WEST SUSSEX COUNTY COUNCIL CONSULTATION

TO:	Arun District Council FAO: Leanne Richardson
FROM:	WSCC – Highway Authority
DATE:	11 November 2024
LOCATION:	Land at Woodgate Nurseries Lidsey Road Woodgate
SUBJECT:	AL/89/24/OUT Outline planning with all matters reserved (except access) for the demolition of existing redundant nursery buildings and other structures and erection of a residential development of with up to 130 No dwellings, informal and formal public open space, landscaping, drainage, and other associated works. This application may be a Departure from the Development Plan. Technical note received.
DATE OF SITE VISIT:	12 September 2024
RECOMMENDATION:	More information required

This is the second WSCC Highways response to an outline planning with all matters reserved (except access) for the demolition of existing redundant nursery buildings and other structures and erection of a residential development of with up to 130 No dwellings, informal and formal public open space, landscaping, drainage, and other associated works.

Pedestrian/Cycle Access (HTp/2401/04/C)

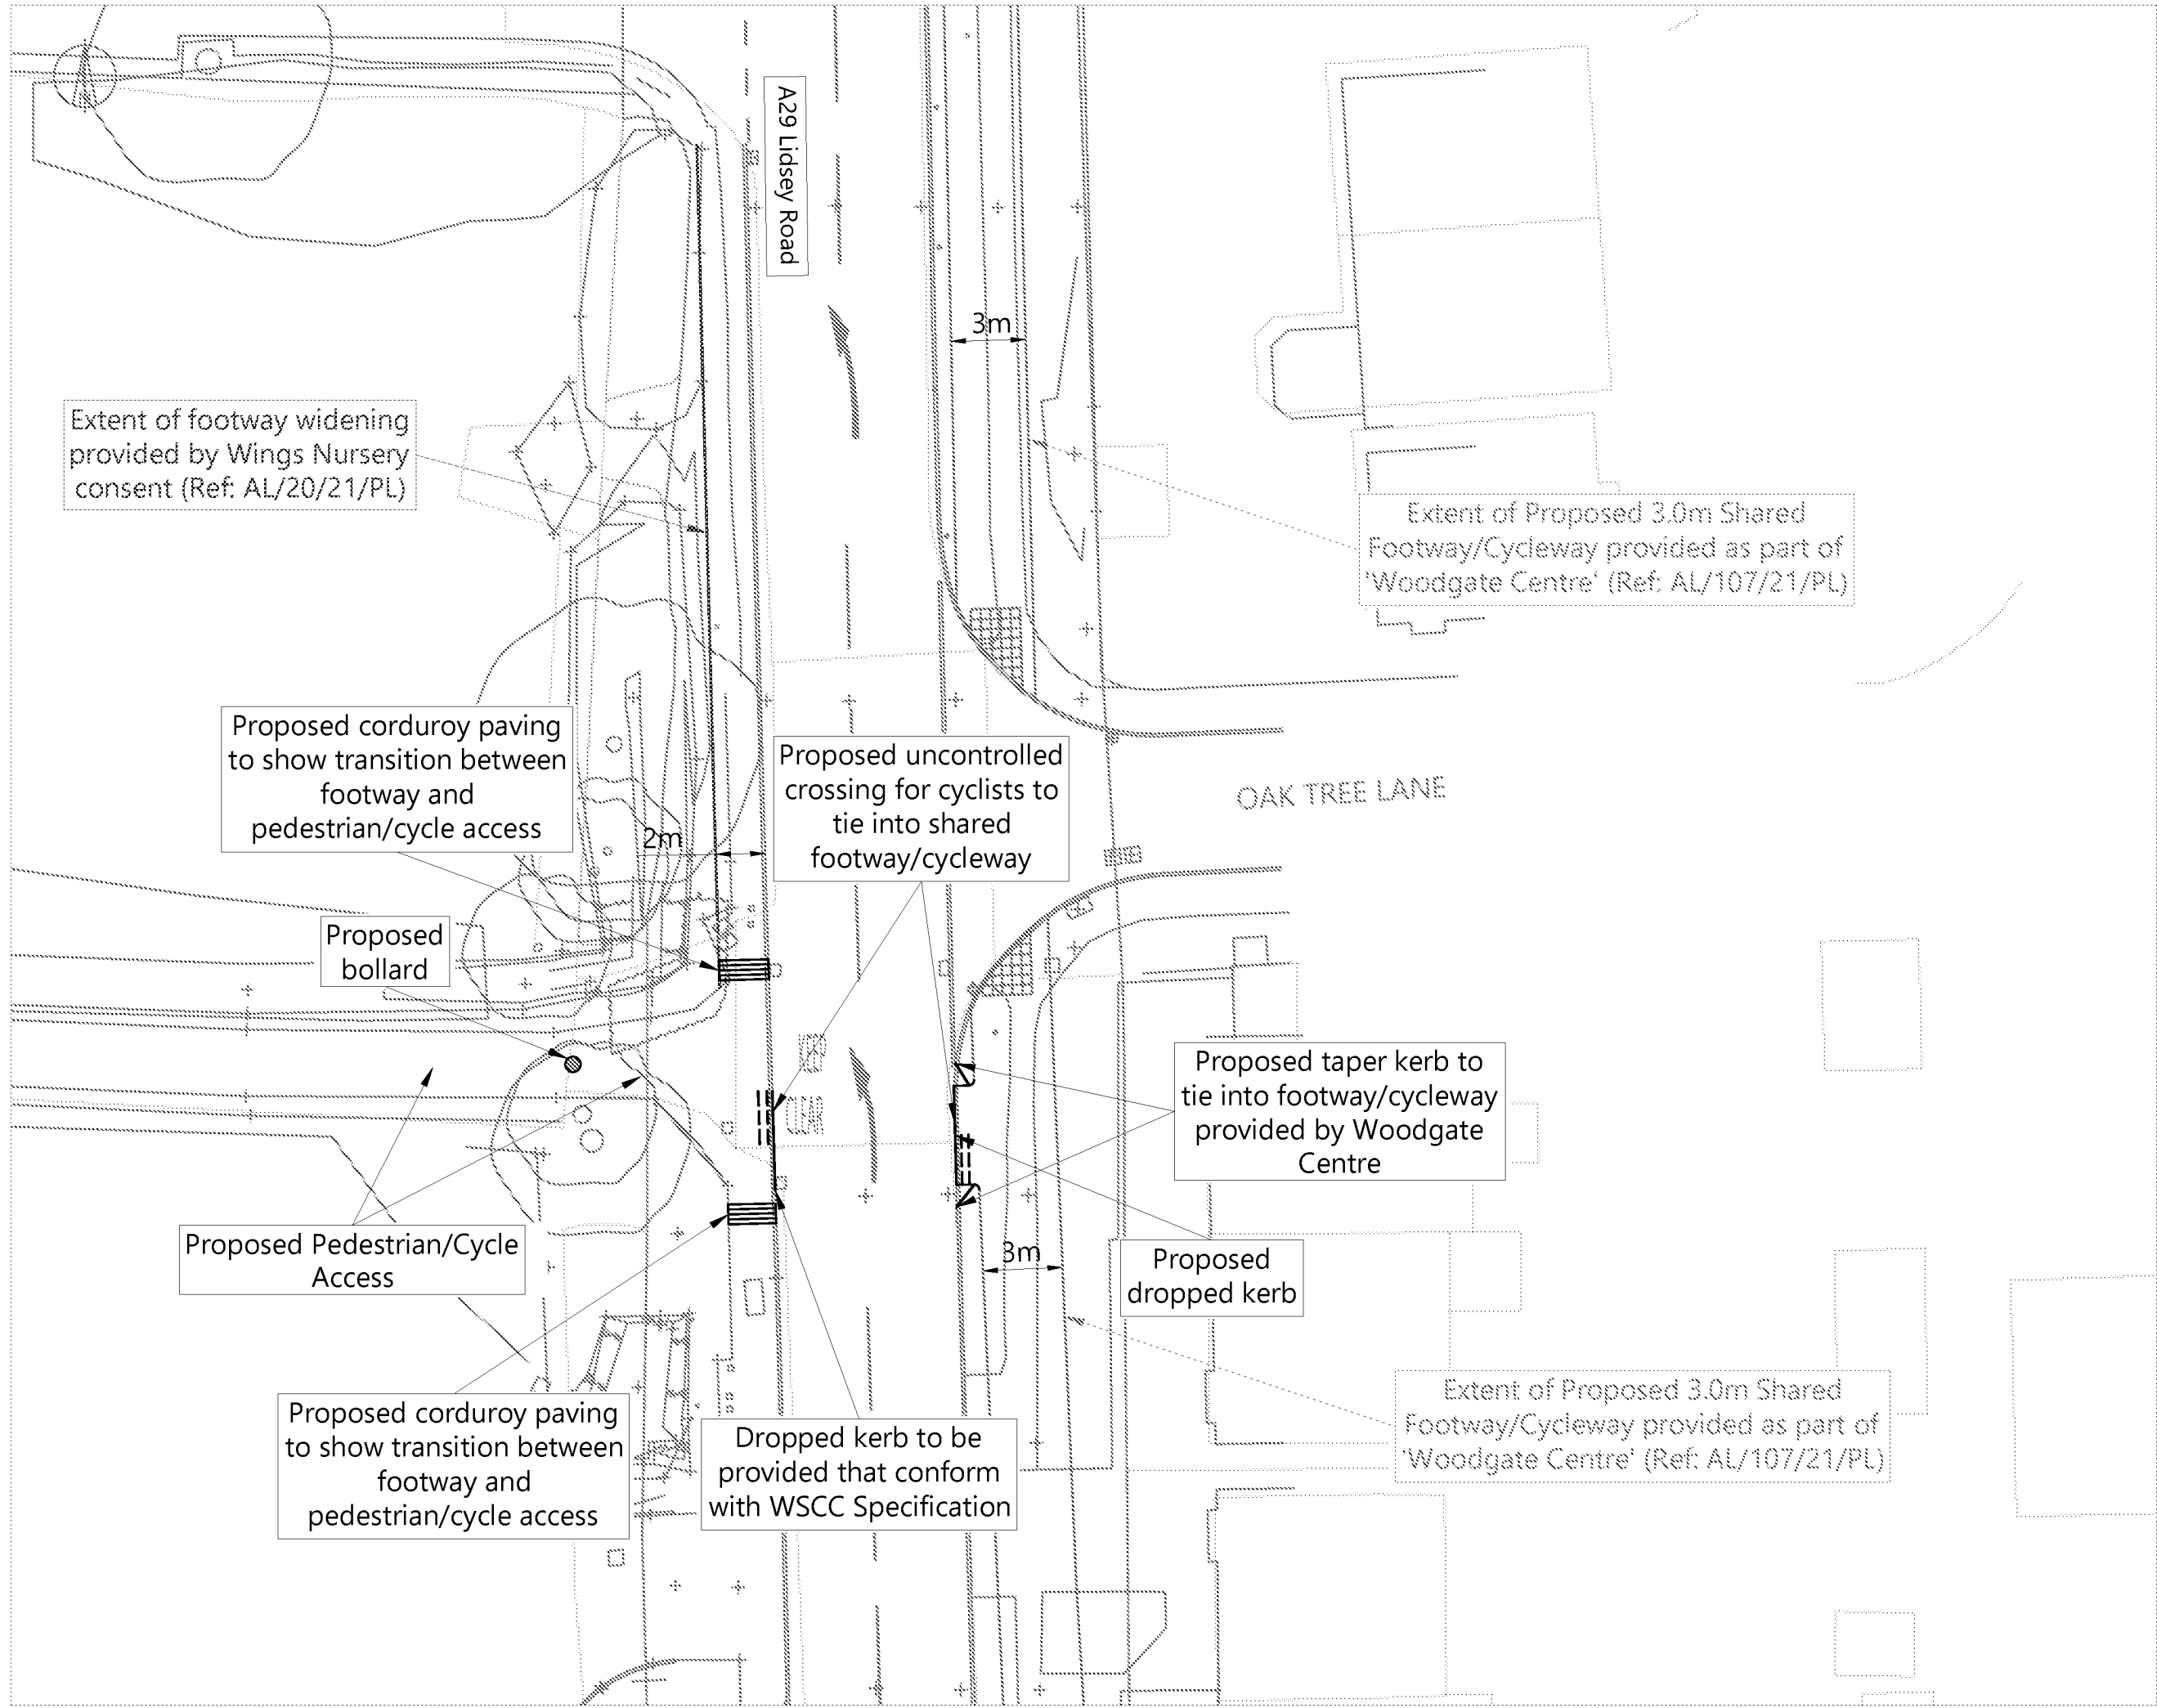
3. Plan to be provided showing the design details of the foot, cycle (and emergency vehicle?) connection to A29 Woodgate Road. Plan should show how the proposed works interface with those works proposed as part of the nearby Woodgate Centre off-site foot and cycle works. *This has now been provided (see Drawing No. HTP/2401/04/C. Final details of markings, lining and signage to be provided at detailed design stage.*
